<b>PROPOSAL:</b> Outline application for erection of 56 dwellings and care home with associated parking.	Ref. No.	DD60
	Officer	Christina Lee
	Tel No.	01484 225729
	O.S. Ref.	414830, 409296
<b>LOCATION:</b> Former Midlothian Garage, New Mill Road, Holmfirth	Date Received	10/12/2015
	Date Returned	04/01/2016
	Site Area	Approx. 2.3 hectares
<b>NOTES/COMMENTS</b>		
<p>A standard proposed housing estate layout. It is a proposal for 53 houses comprising of 9 different layouts and designs, 3 no. 1 bed roomed apartments and a care home.</p> <p>Consideration needs to be given to materials used for road surface, particularly the brindle setts and their construction and installation to withstand regular bin wagon visits and other heavy loads. Design / location of bin stores needs to be considered and ease of access / turning capacity for waste collection. This is particularly pertinent at the affordable units and apartment location where access is from New Mill Road and space within this area appears limited, particularly if the car park is at full capacity.</p> <p>On the Estate Road near to Mews Court, there is an odd arrangement with the footpath layout where it appears residents will need

TITLE SITE PLAN

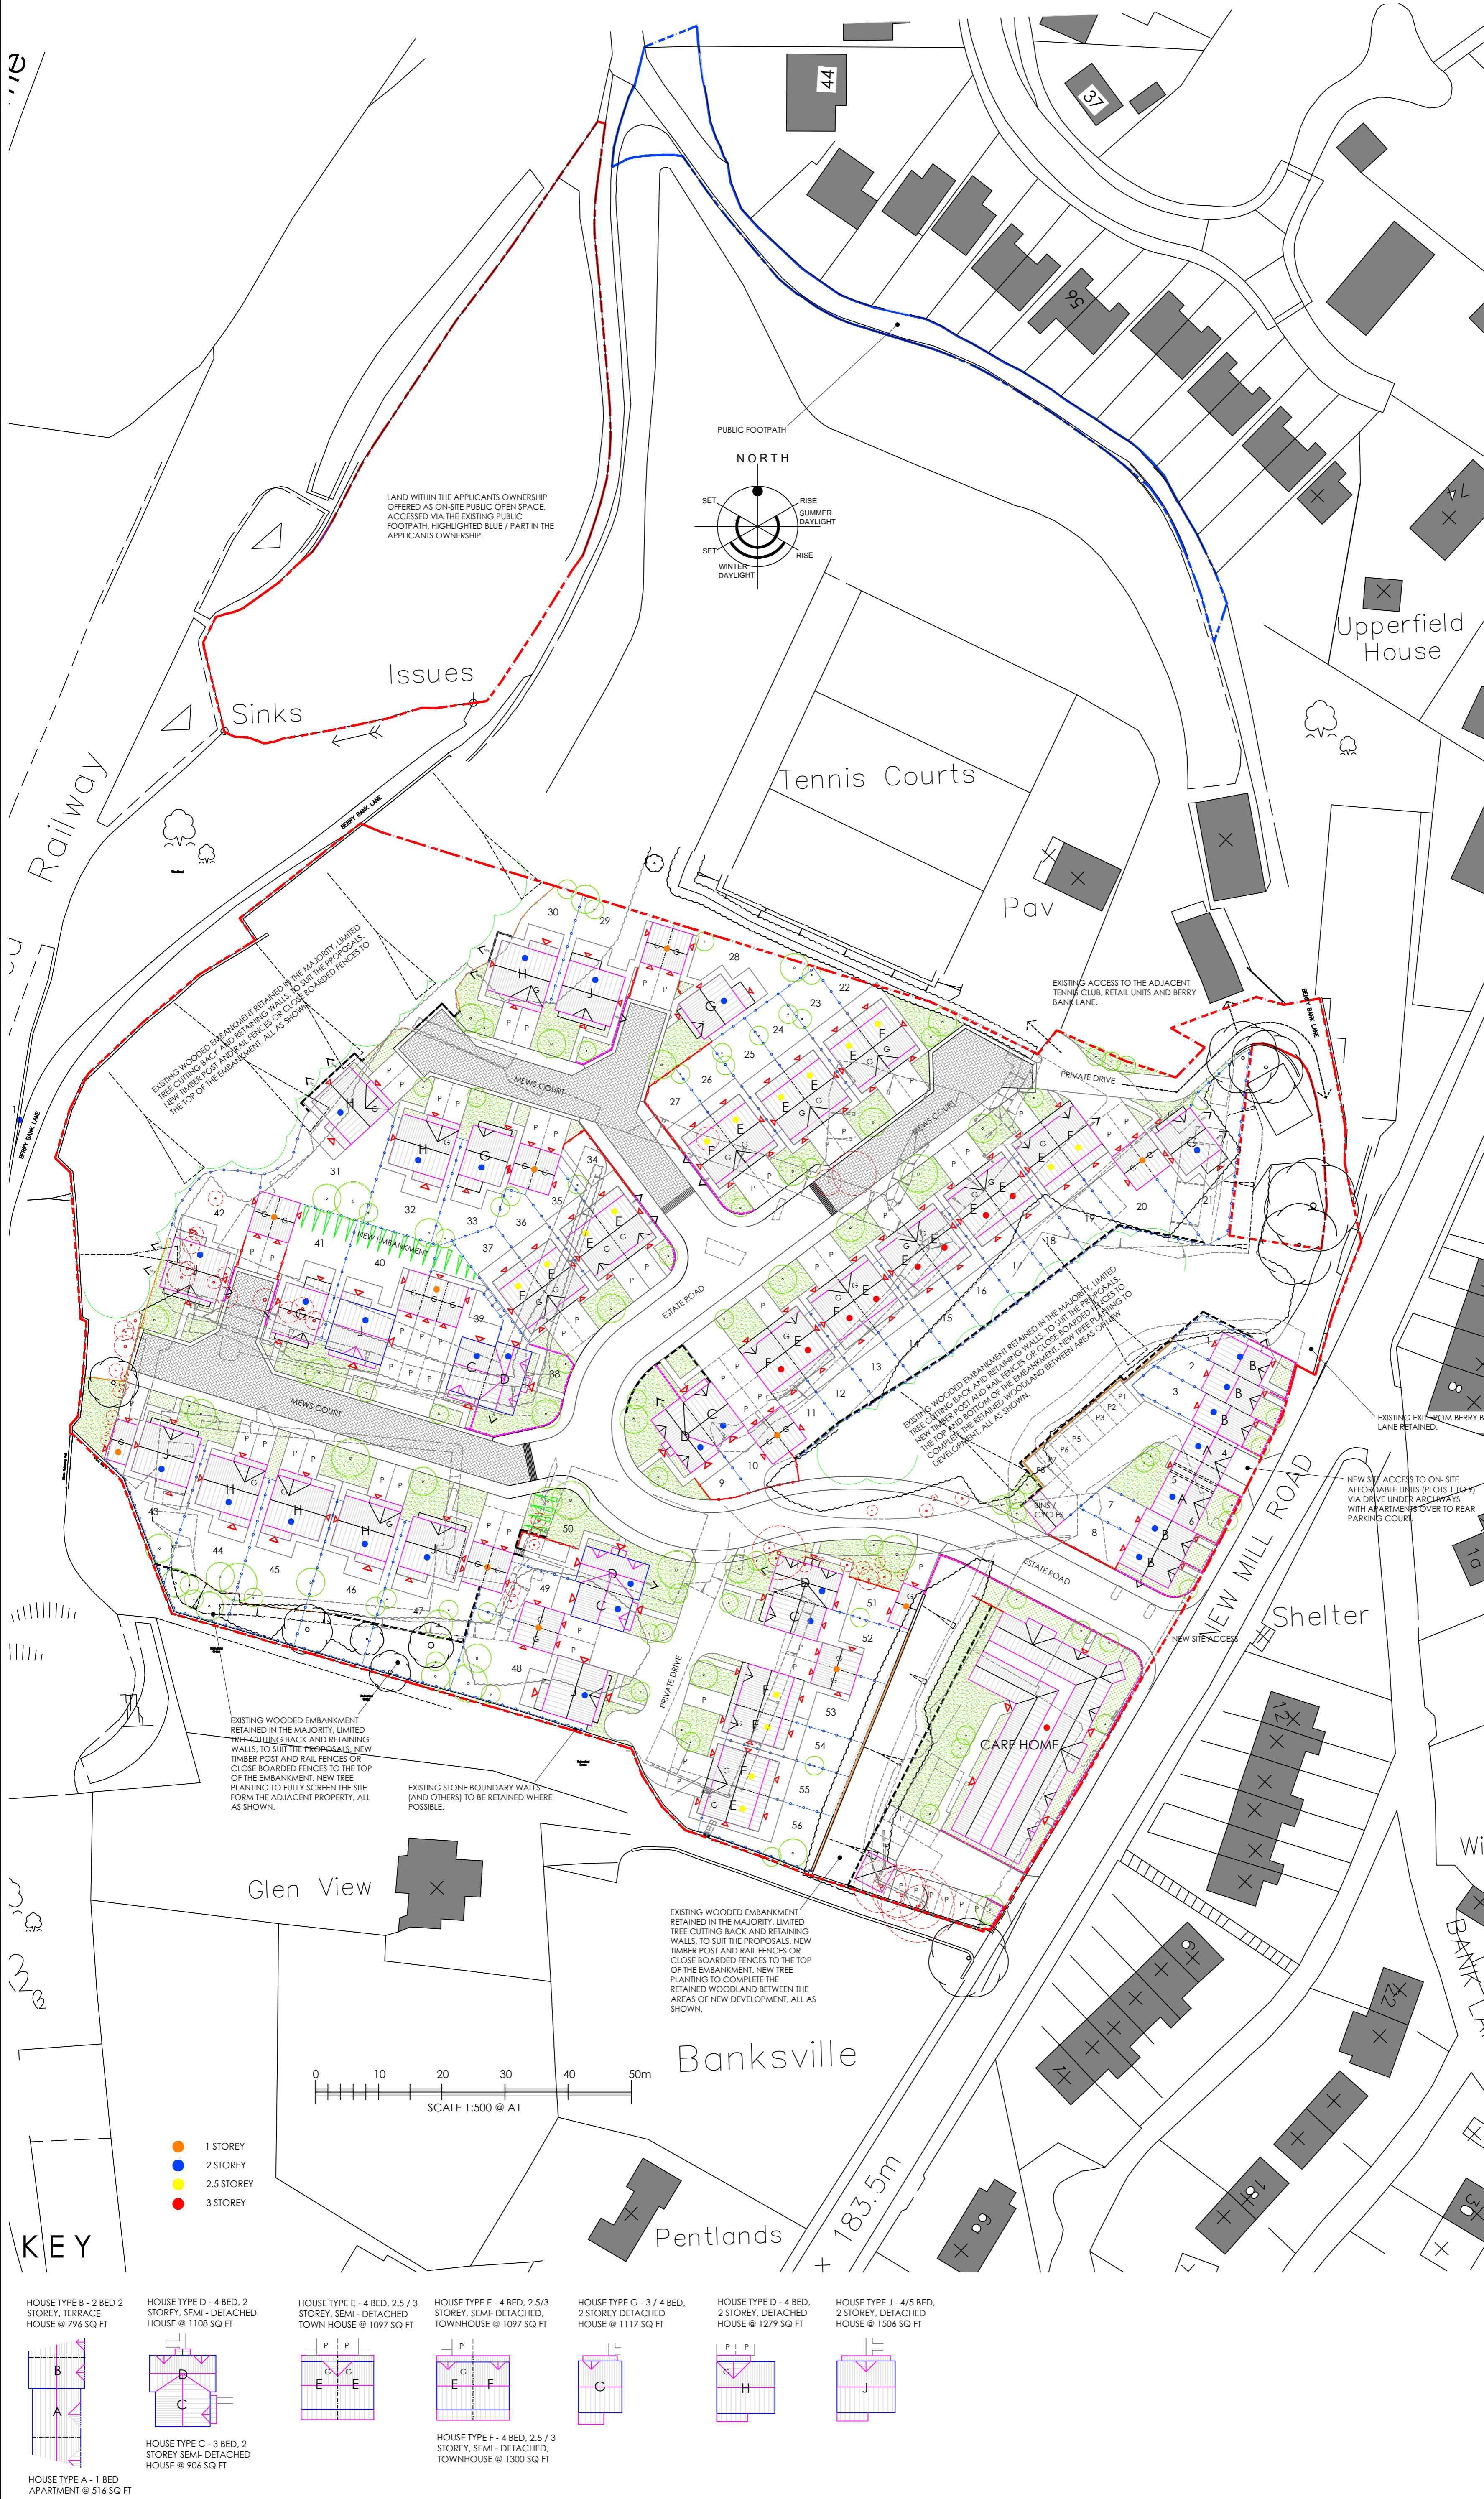
The POS is not within the estate or directly linked. There does not appear to any footpath from the development to the POS so there are questions re: access and associated land ownership. In addition, it appears the POS will remain as it presently is, therefore providing negligible enhancement to the development. We would therefore recommend, without prejudice, an off-site contribution of £144,900.00.
